KITTITAS COUNTY COMMUNITY DEVELOPMENT SERVICES

Subject: Suncadia Phase 2 Division 1 (LPF-21-00004) Final Long Plat – Staff Review, Return of Application-Additional Information Required.

LP-20-00003
LPF-21-0000X

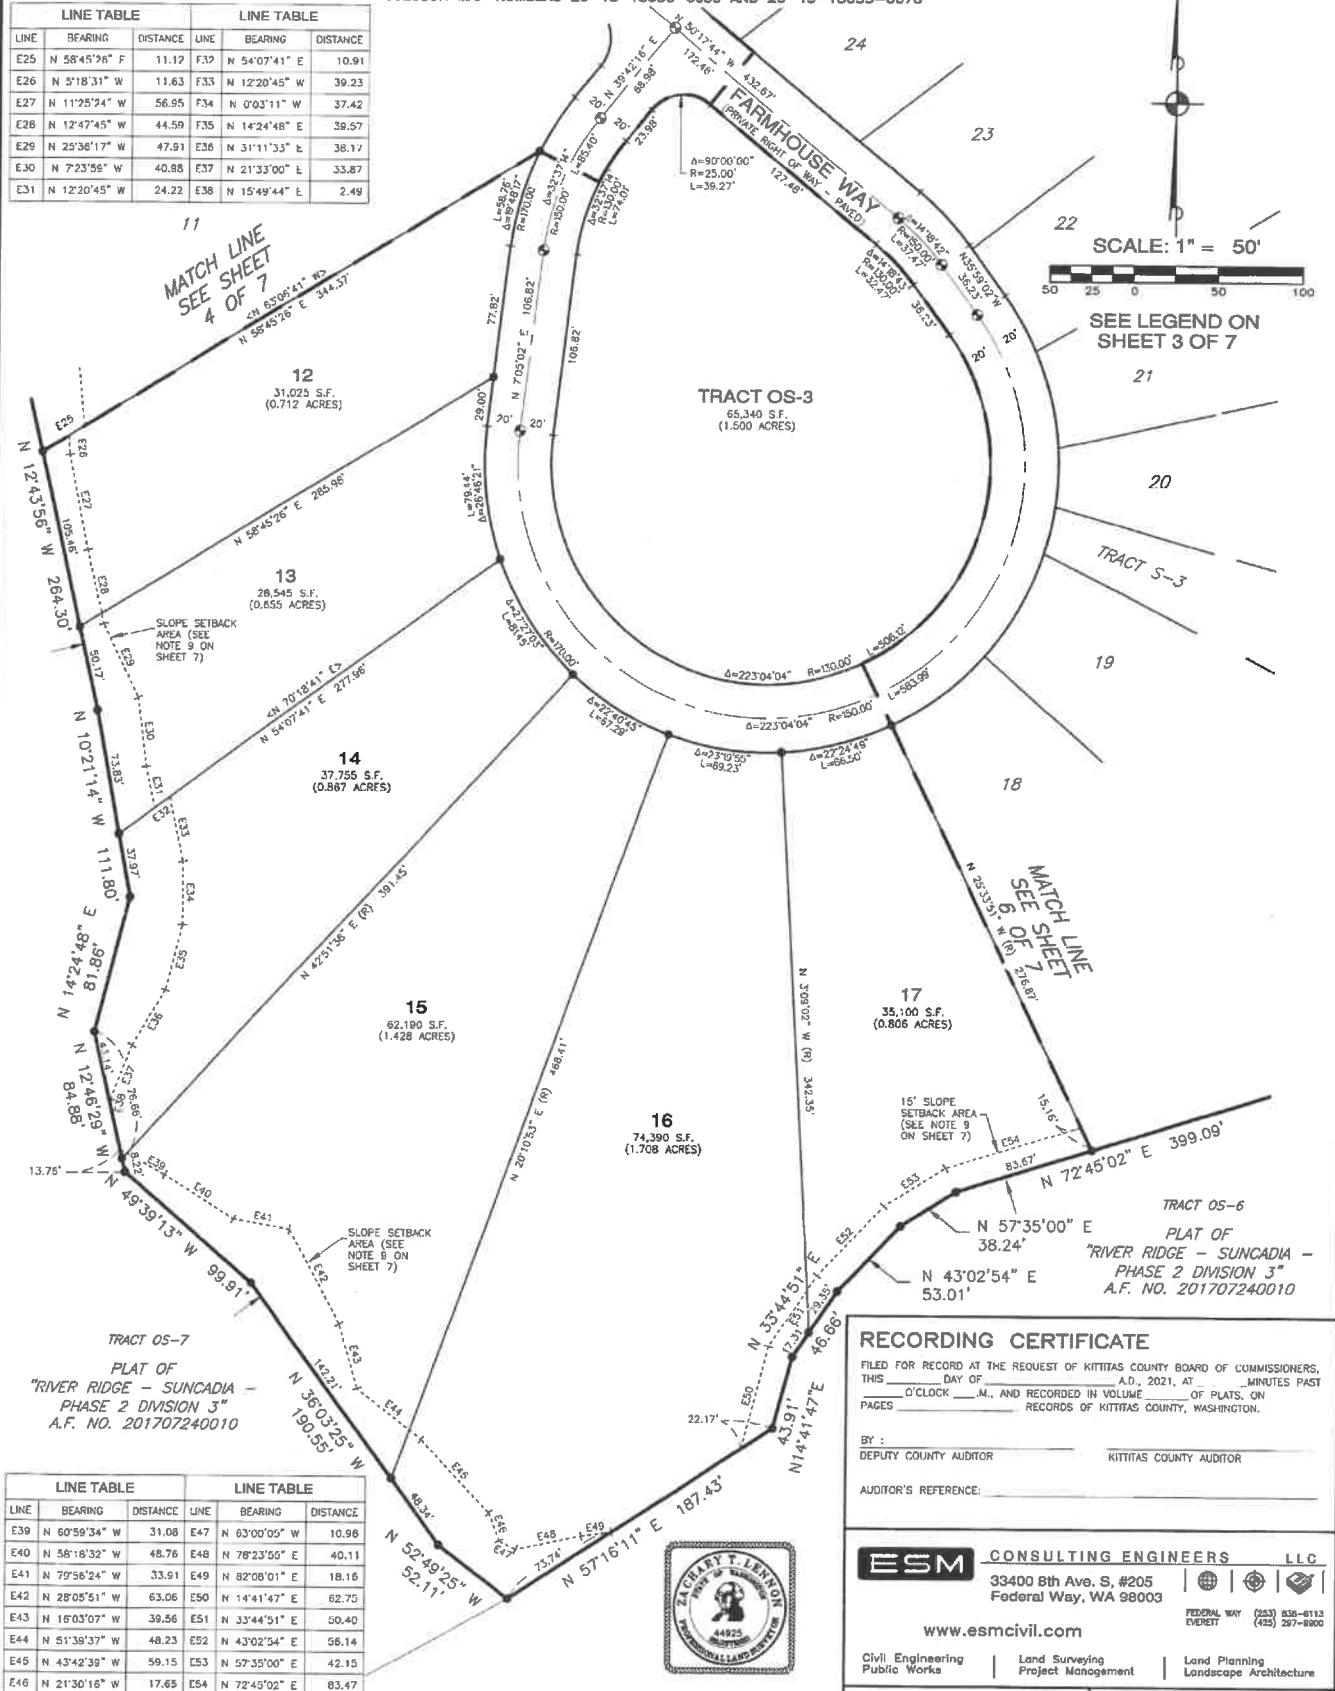
- The final mylars shall note the final plat file number LPF-21-00004 on the face of the plat in addition to the preliminary approval number already noted.
- Taxes on parcel #960514 and 960534 must be paid in full before final signature.
